Project: C.D. REZONING PLAN FOR NISBET OIL CO.
Sheet Title: SUNSET ROAD AT I-77

REVISED FOR PUBLIC HEARING: PETITION #90-85

SUBJECT: Administrative Approval for Petition No. 90-85, Tax Parcel #037-129-12

SUBJECT: Administrative Approval for Petition No. 90-85 by Nisbet Oil Co. Tax Parcel # 037-129-12

C.D. REZONING PLAN FOR NISBET OIL CO. SUNSET ROAD AT I-77

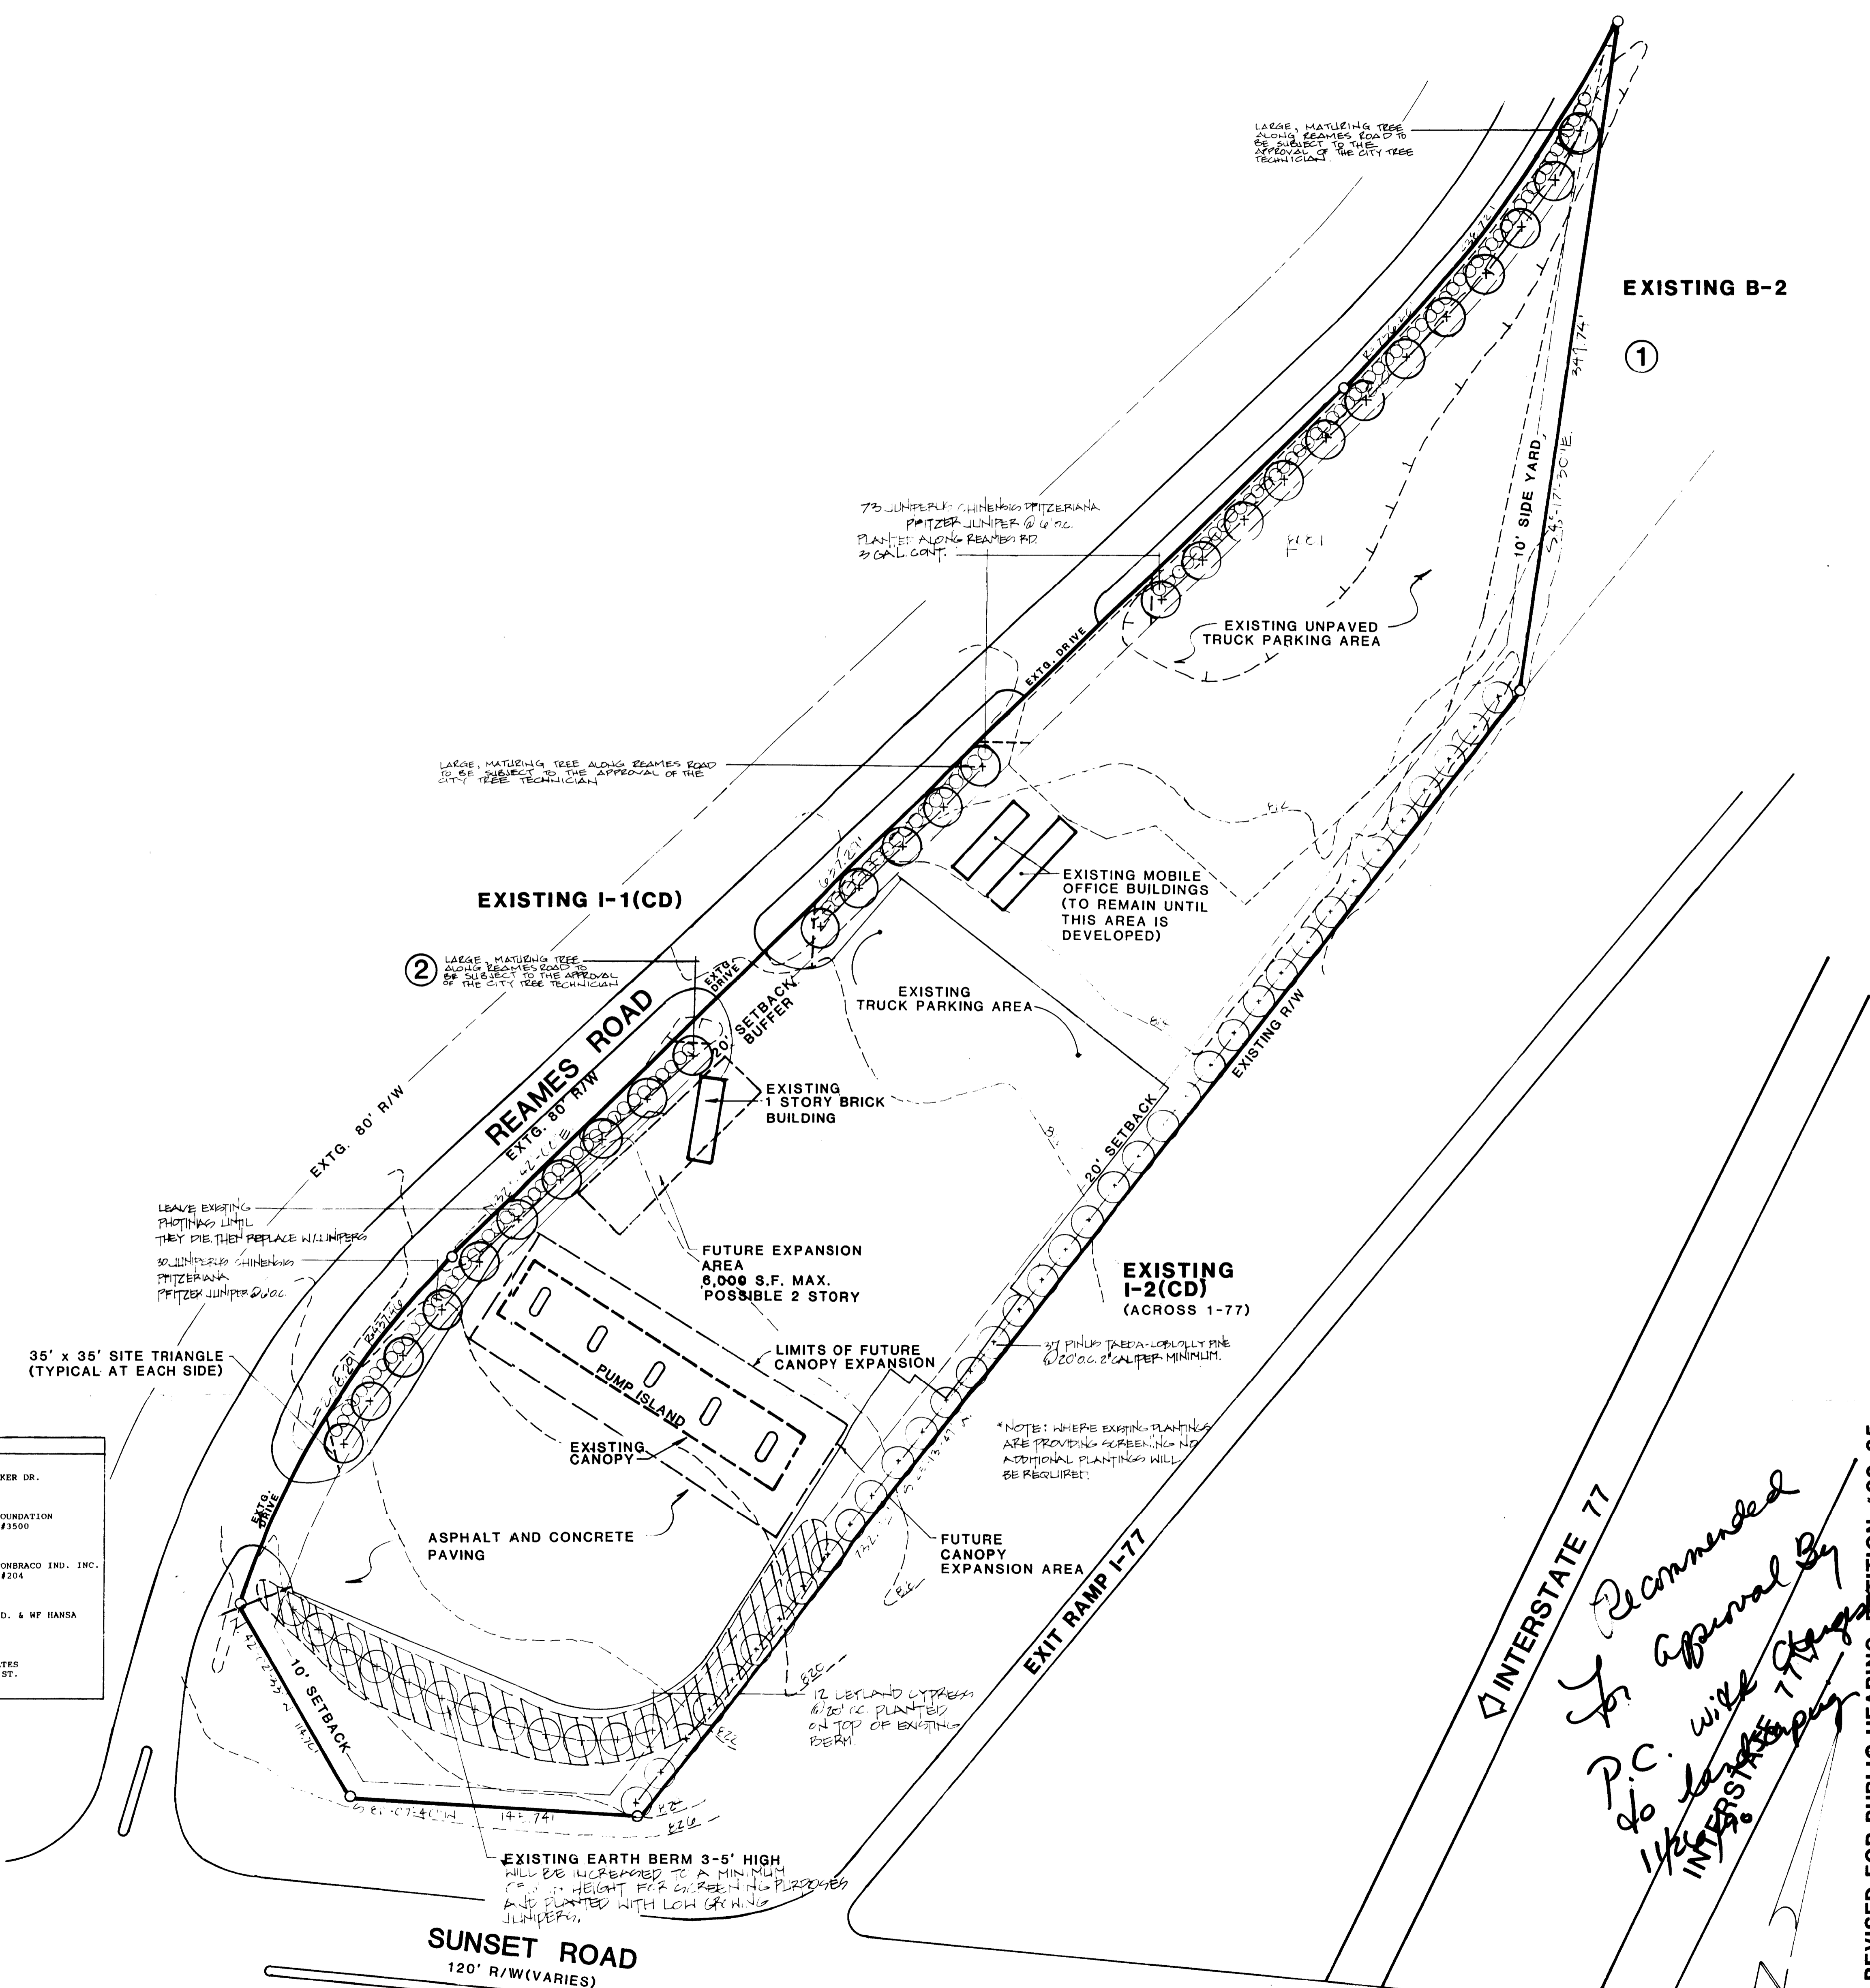
Attached is a revised plan for the above mentioned rezoning petition. The plan has been revised to add a set of truck scales and a dumpster enclosure. Since these changes are minor in nature and do not effect the yards at the exterior of property I am administratively approving this plan. Please use this plan when evaluating requests for building permits and certificates of occupancy.

Attached is a revised plan for the above mentioned rezoning petition. The plan has been revised to move one of the proposed driveways along Reames road closer to Sunset Road and to show a different building and canopy orientation than originally approved. The new building will not exceed the total square footage allowed by the rezoning plan or encroach into the required yards. One of the existing driveways along Reames Road will be closed as part of the relocation and opening of the new driveway along Reames. Since these changes are minor I am administratively approving this revised plan. Please use this plan when evaluating requests for building permits and certificates of occupancy.
